## Department of Primary Industries

### **Prestons Warehouse and Distribution Centre (SSD 7155) Comment on the Environmental Impact Statement**

Mitchell Isaacs  
**Director, Planning Policy & Assessment Advice**  
20/04/2016

Drawing:
SHADOW DIAGRAMS

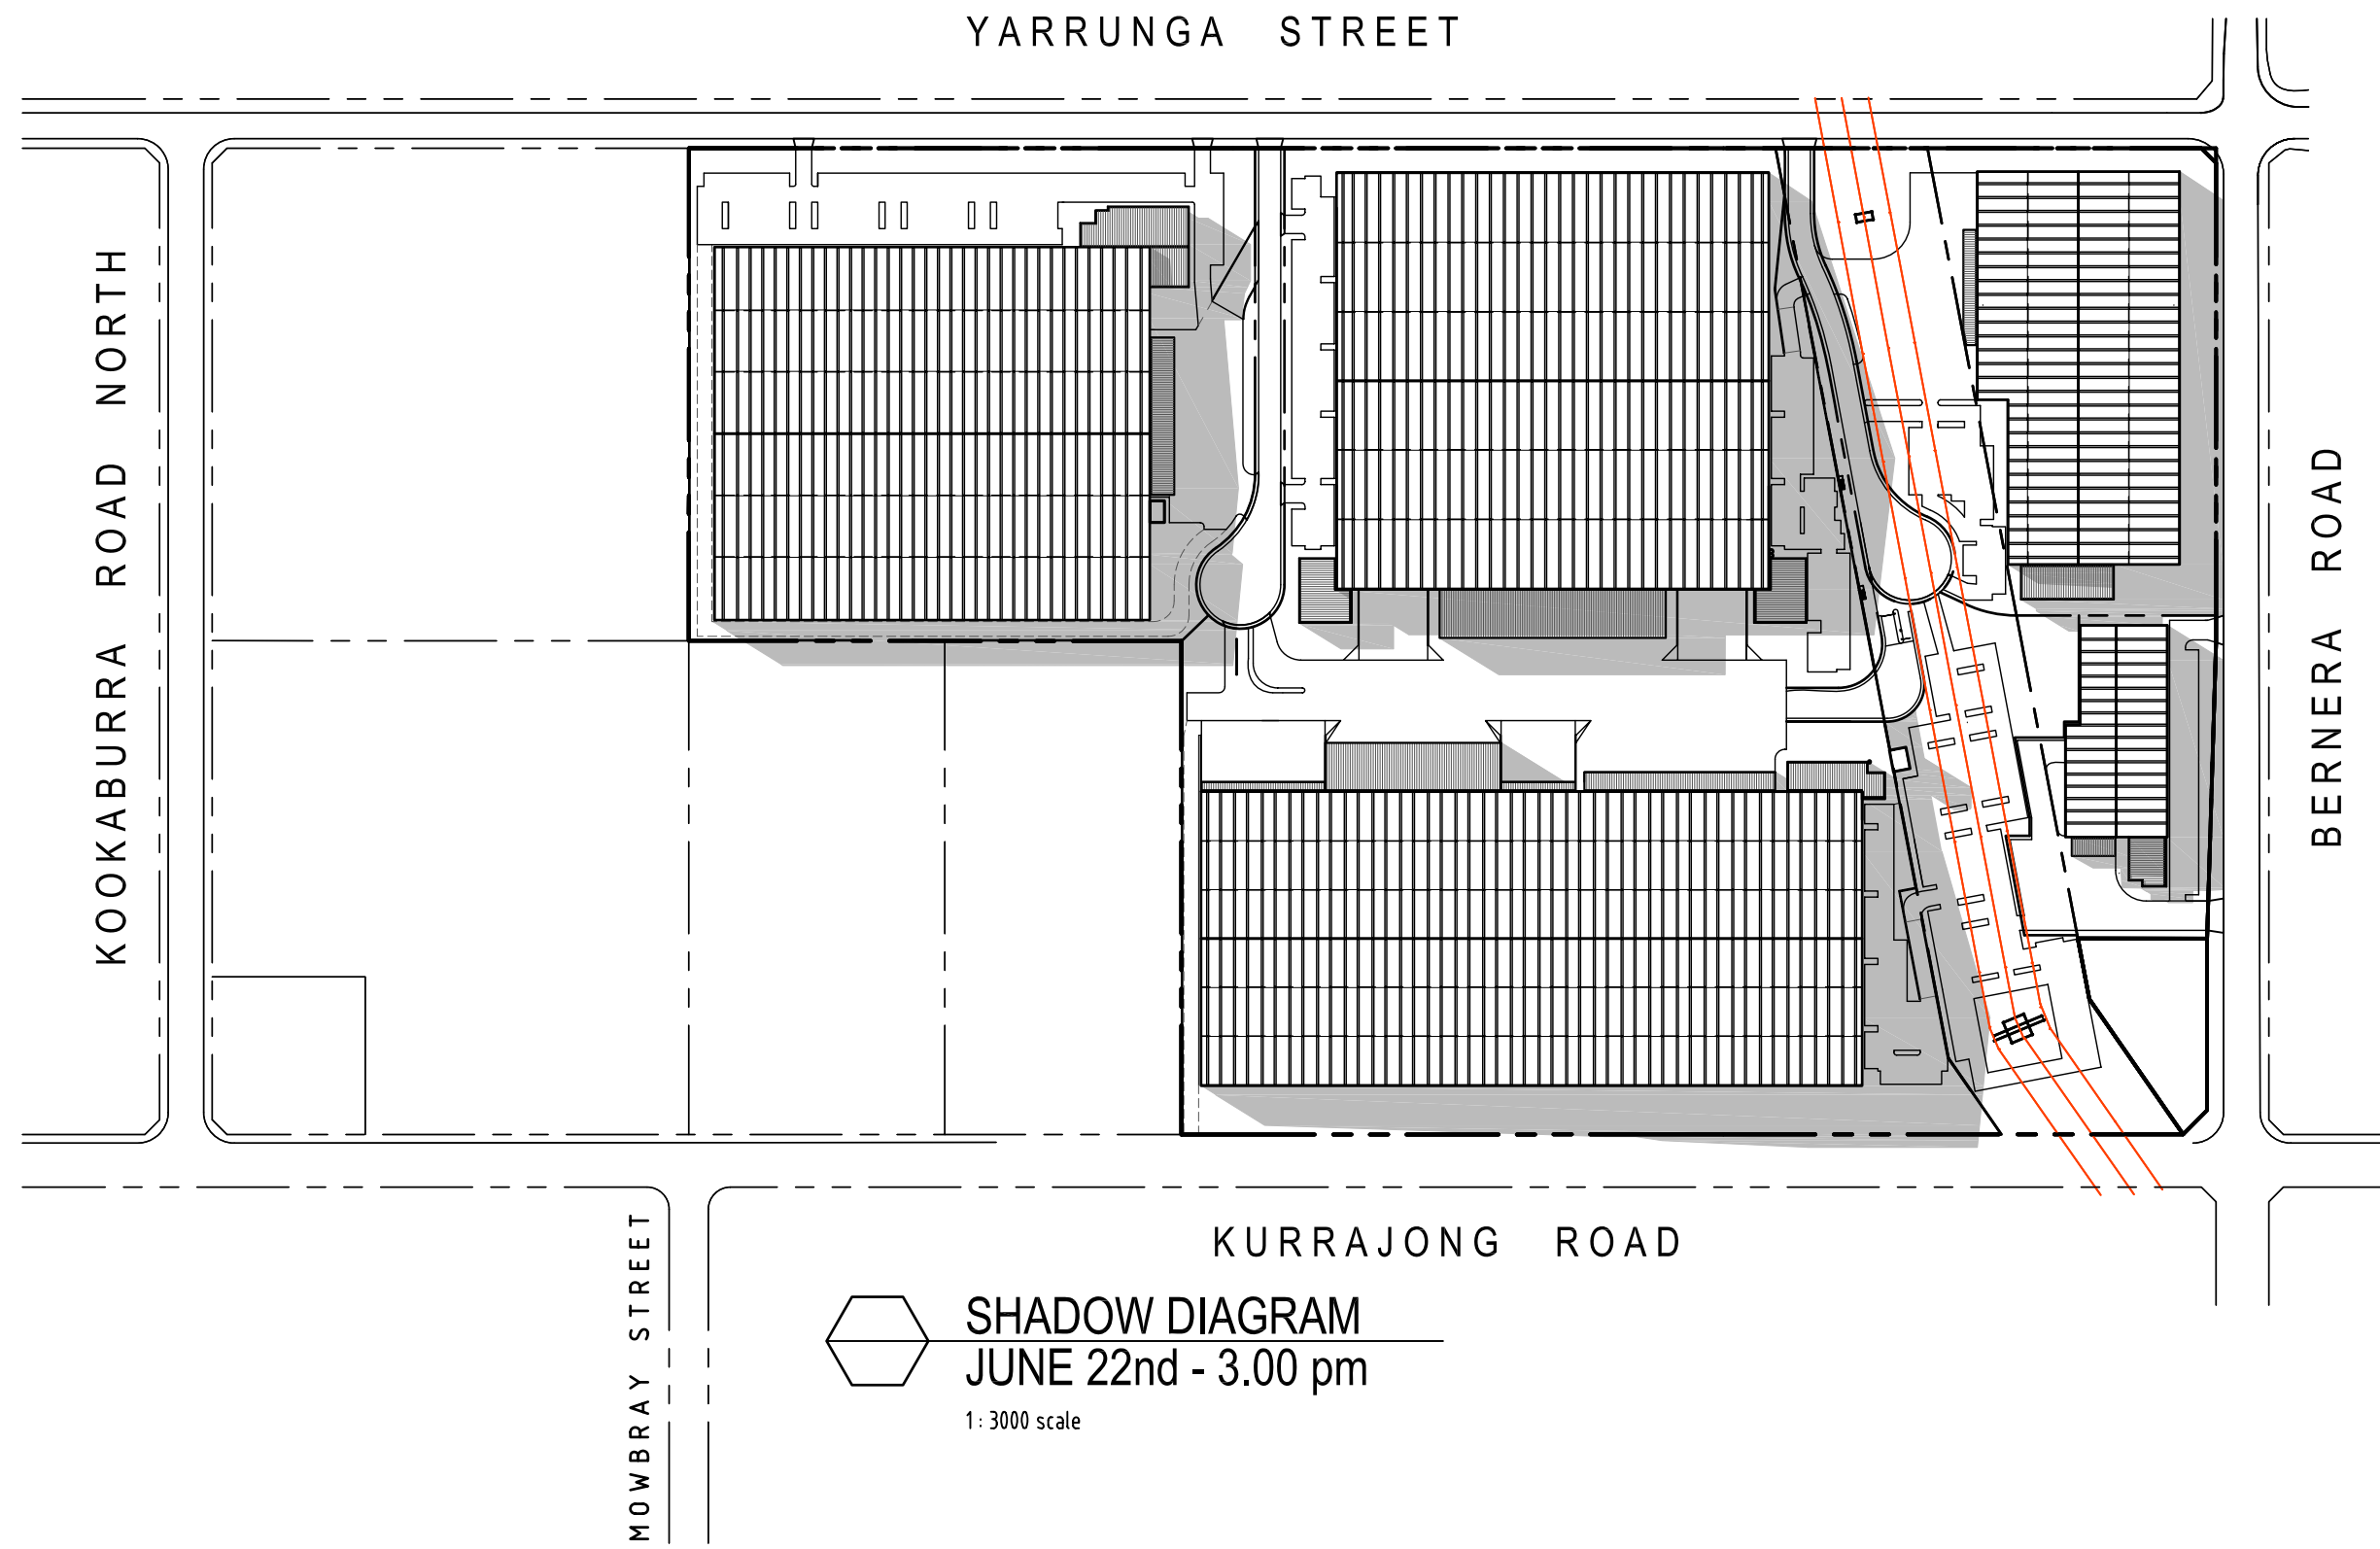
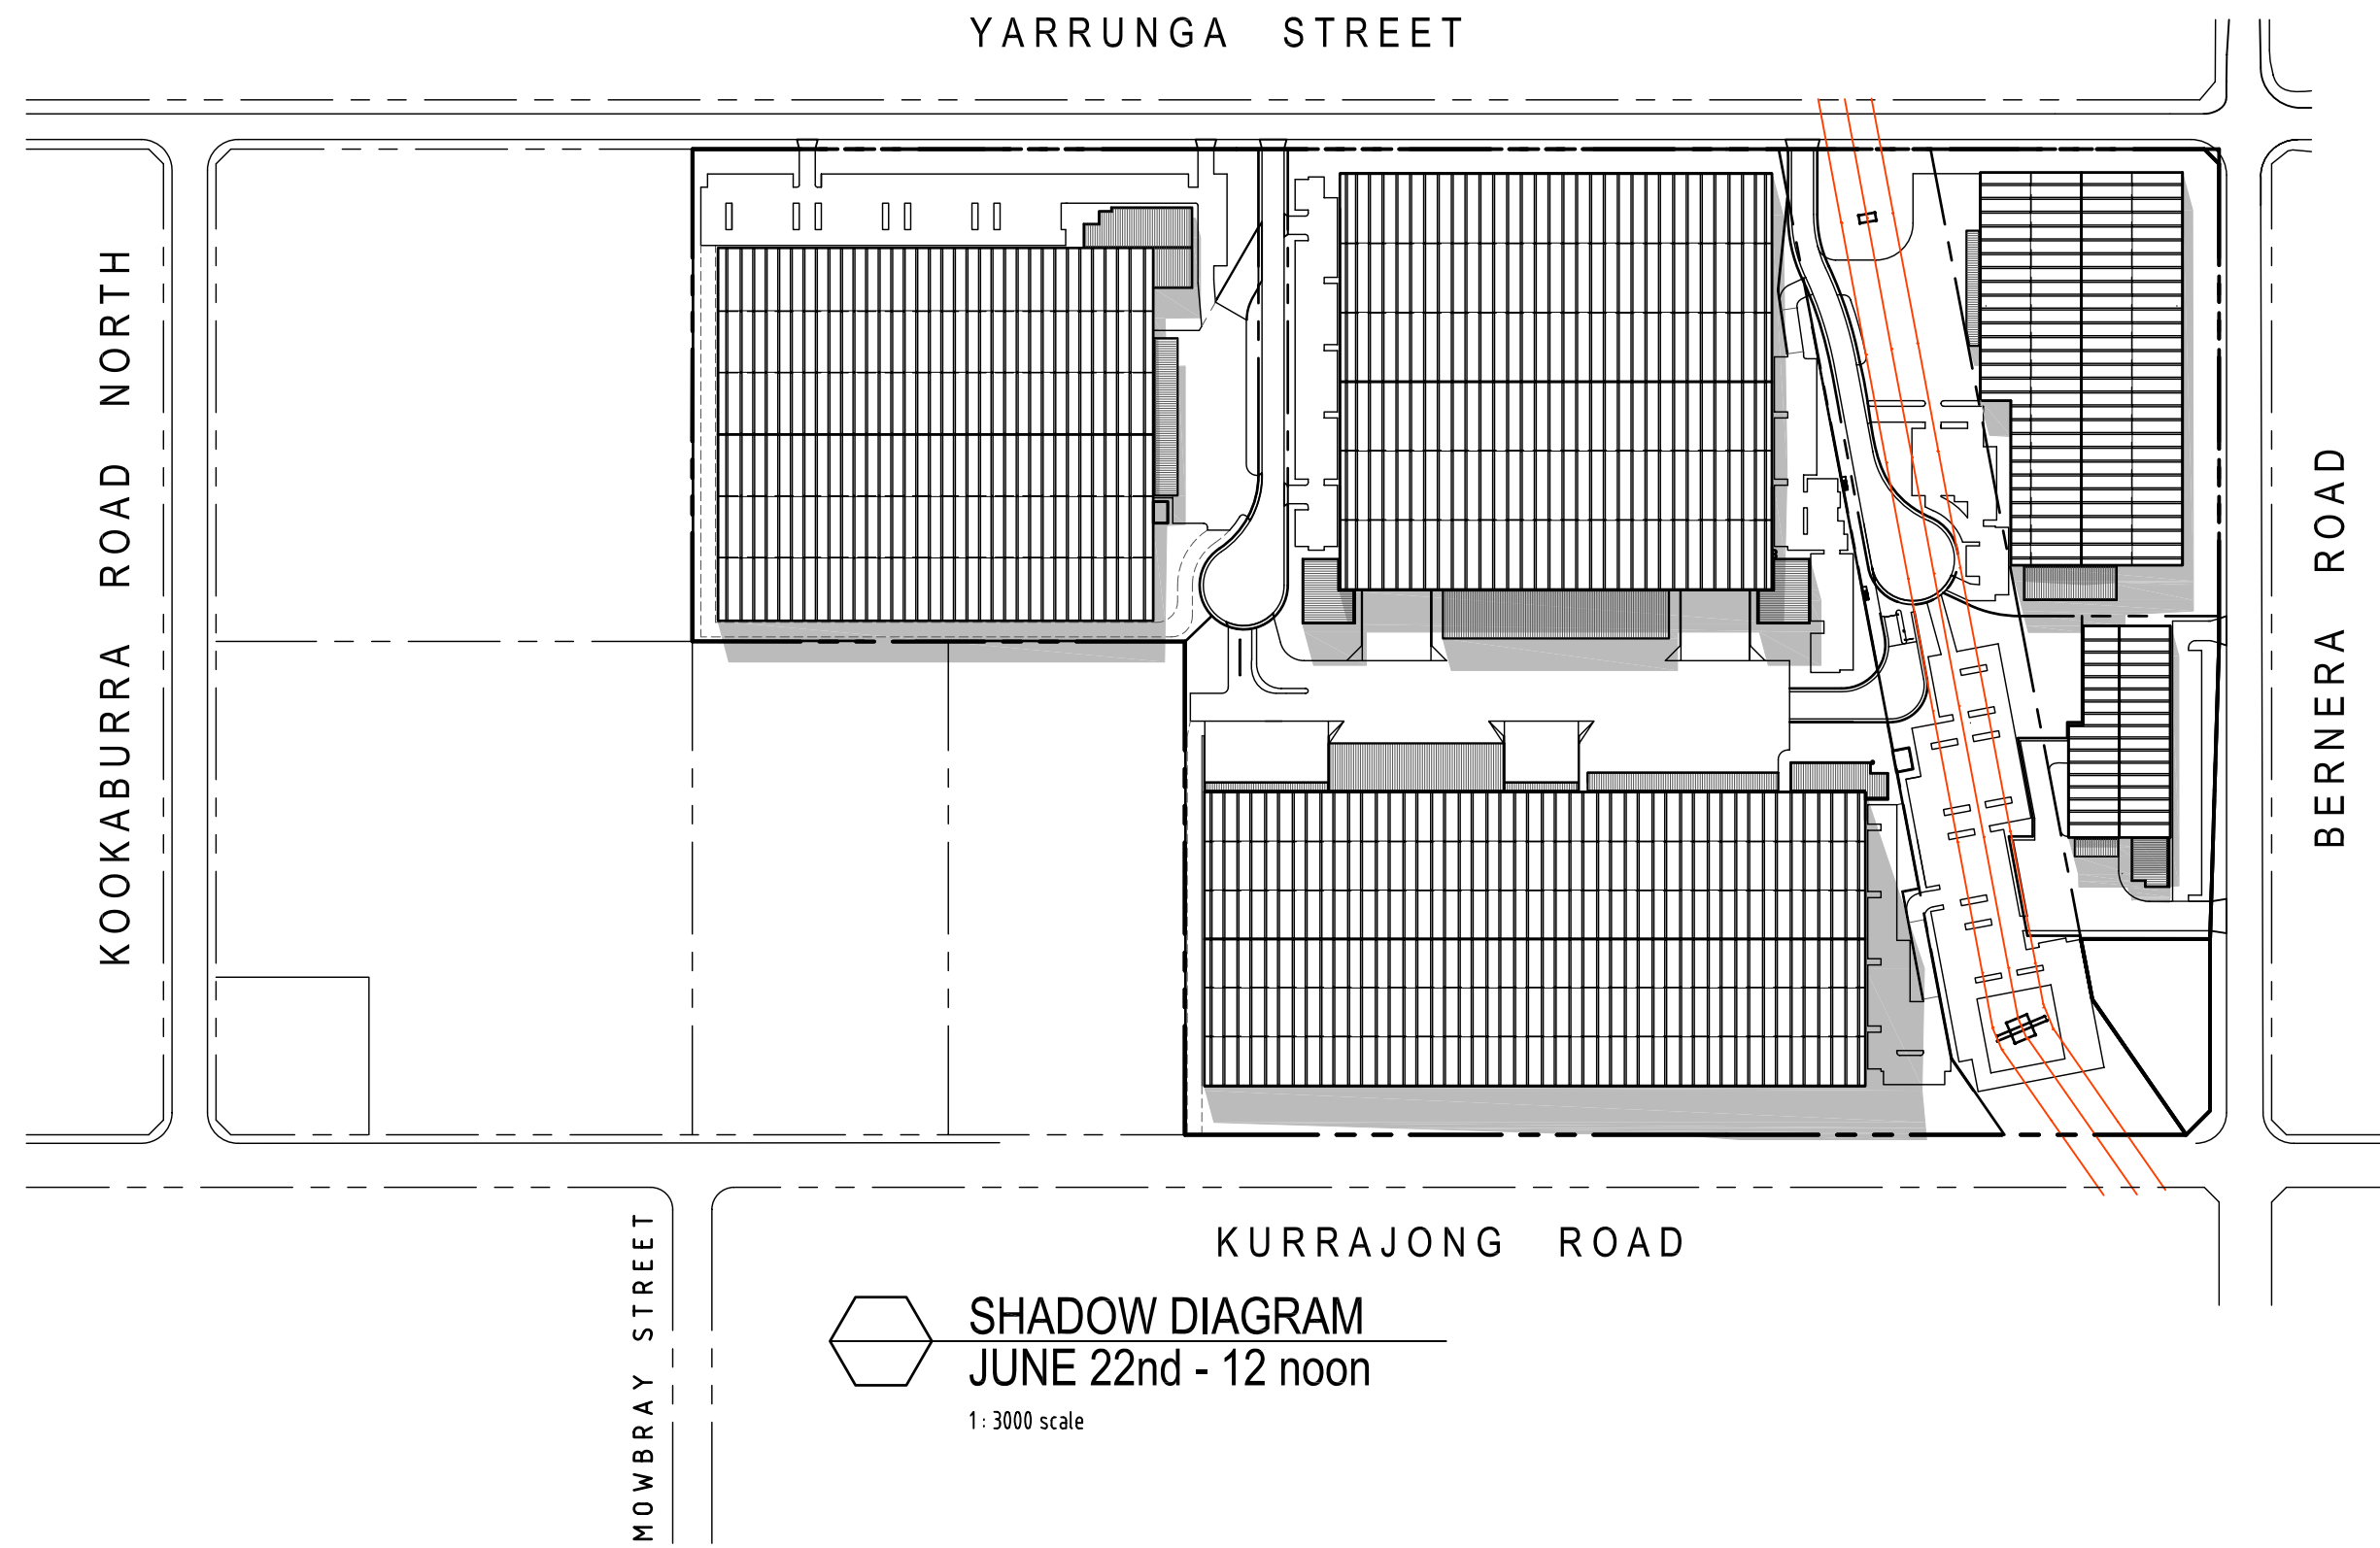
The EIS mentions agricultural activities to the west of the site for the warehouse (*'West - Similar to subject site. Predominantly undeveloped, grass covered sites with evidence of market gardening, p 20.'*) The EIS and a desktop inspection note greenhouse horticulture (see figures at Attachment A). The proponent will need to ascertain whether the adjoining

market garden is still operational, and if so, consider whether any overshadowing of the production area by the warehouse is a concern for the market garden operators.
